M3 Junction 9 Unique Reference: 20036783

Application by National Highways for an Order Granting Development Consent for the M3, Junction 9 Improvement

Submission

Winchester Action on the Climate Crisis

Appendix C Flow difference plots

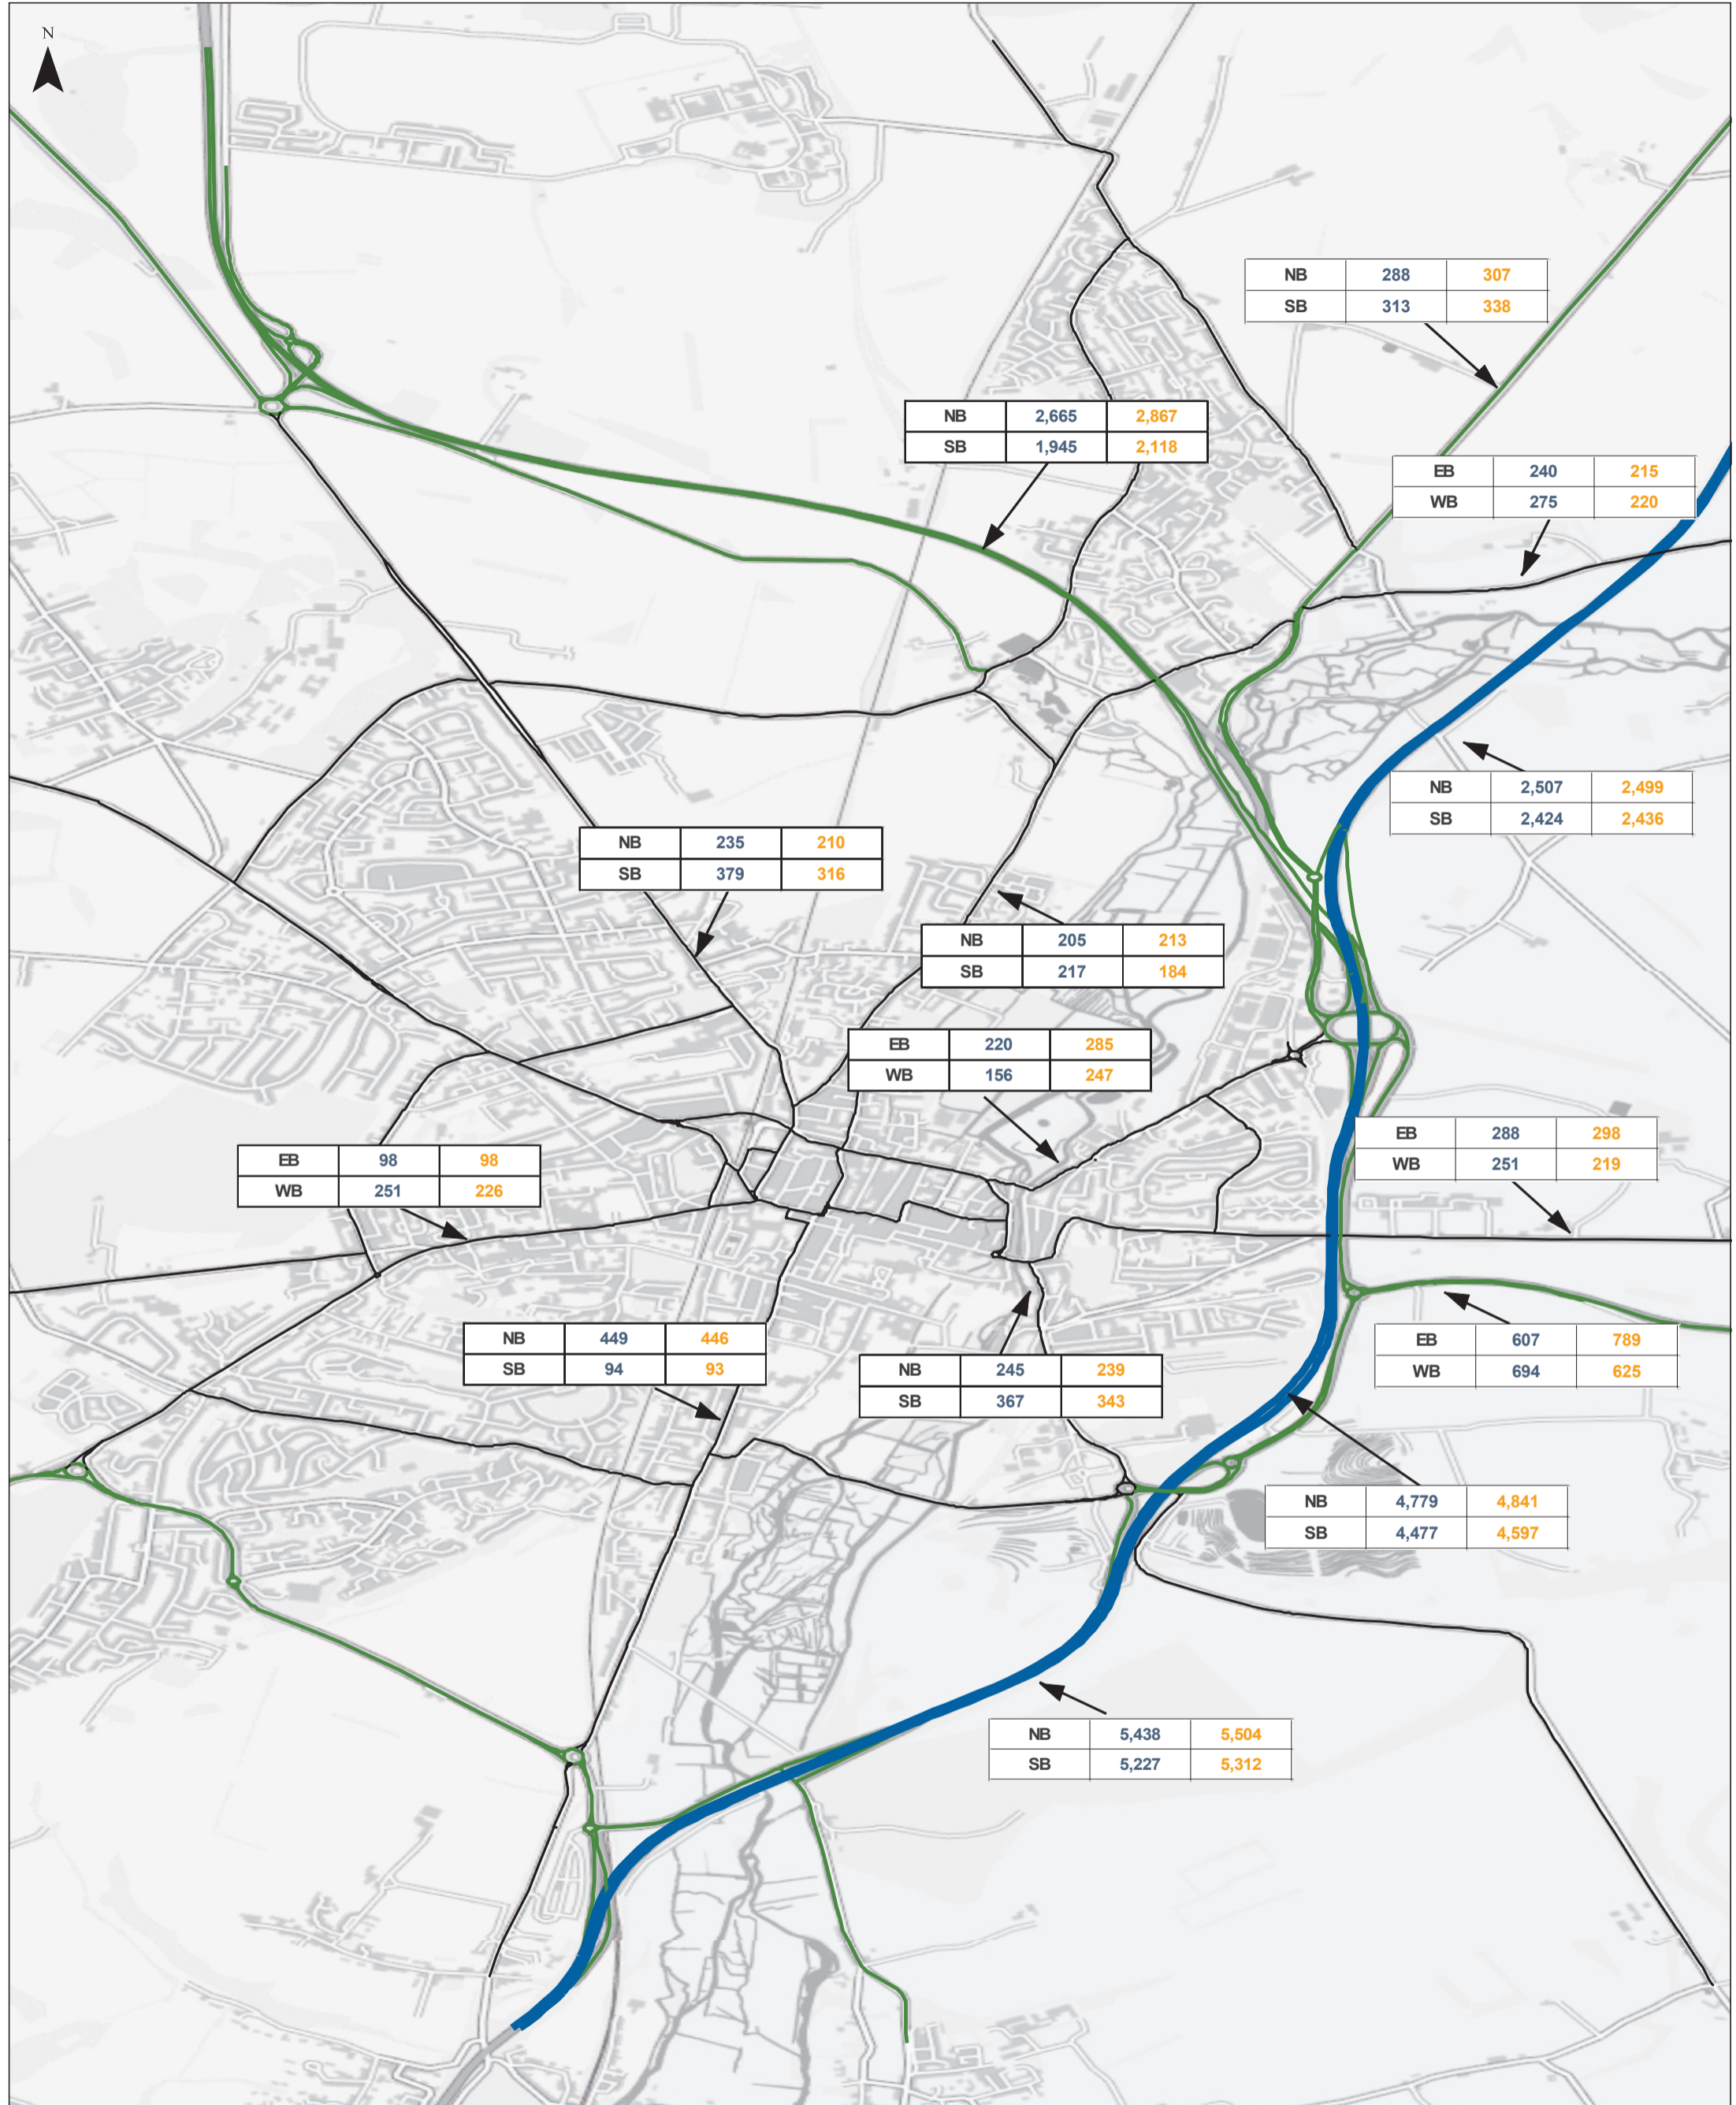
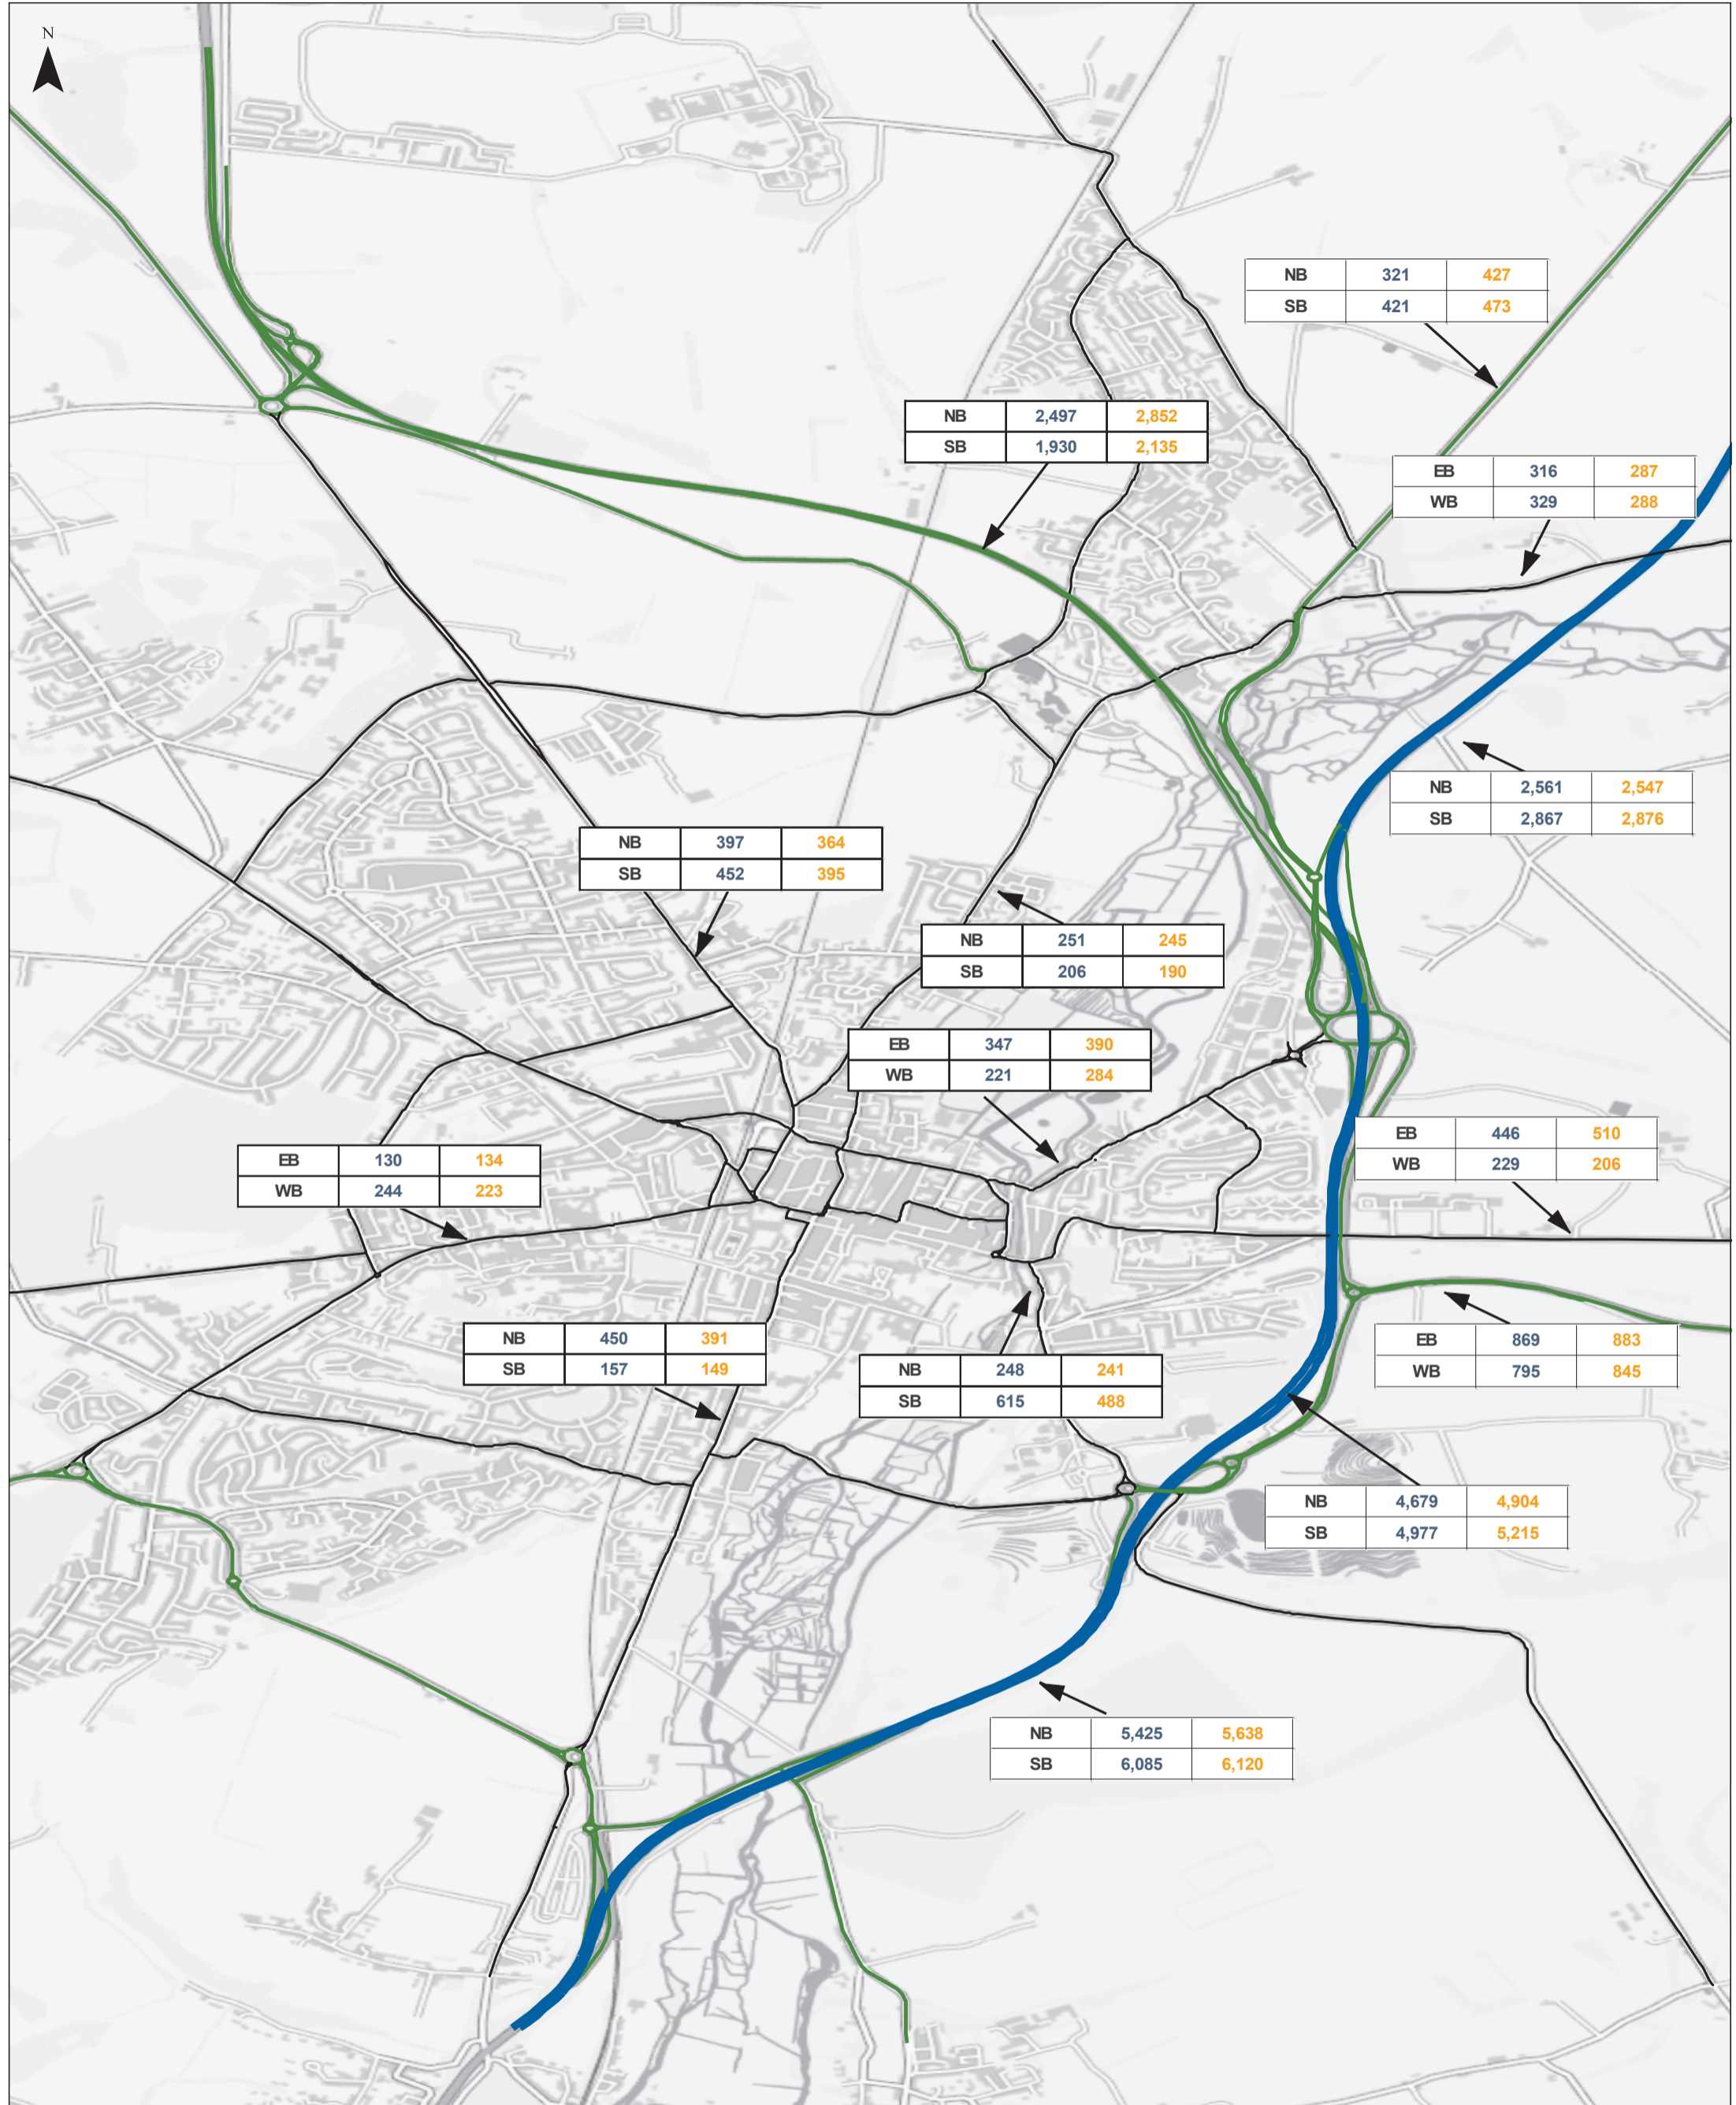
The modelling maps in document [7.10 Combined Modelling and Appraisal Report](#) compare traffic flow if the project does not go ahead (Do Minimum (DM)) with what will happen if the project goes ahead (Do Something (DS)). The final comparison models what will happen in 2047.

In the table below we have added together both directions for the AM peak, the period between the peaks, and the PM peak.

2017	AM+IP+PM		DS/DM%
	Do Minimum	Do Something	
Andover Road	2,843	2,374	83.50%
Romsey Road	1,077	1,092	101.39%
St Cross Rd	2,028	1,779	87.72%
Chesil Str	2,371	1,873	79.00%
Alresford Rd	2,561	2,501	97.66%
Easton Lane	1,712	2,152	125.70%
Worthy Rd	1,640	1,503	91.65%
Petersfield Road	5,392	5,735	106.36%
Local Roads Totals	19,624	19,009	97%
A34N	14,810	17,595	118.80%
A33N	1,986	2,183	109.92%
M3N	17,308	17,260	99.72%
M3 Sports Centre	31,704	32,689	103.11%
M3 Twyford Down	37,455	37,670	100.57%
Strategic Roads Totals	103,263	107,397	104.00%
Full total	122,887	126,406	102.86%

There are some roads that will suffer major traffic increases: especially Easton Lane, and the A34 as it passes through King's Worthy. Some roads will benefit from major decreases such as Chesil Street and Andover Road.

However the overall picture is one of very little change. It is very surprising that the modellers predict a small reduction in traffic along the M3 from Winchester to Basingstoke. It will reduce traffic levels within Winchester Town very little.

The report above accepts that induced demand is a significant phenomenon. In the worst cases, especially where there is traffic congestion, traffic will increase to fill the available space. The applicant proposes doubling (at least) the carriageway width on the route through the junction linking M3S and A34N in both directions. In a situation like this it would not be unknown for traffic to double. This route does show the greatest two-way traffic increase across the 20 year modelling period but the increase of 26% predicted by the modelling understates the likely results of a 100% capacity increase:
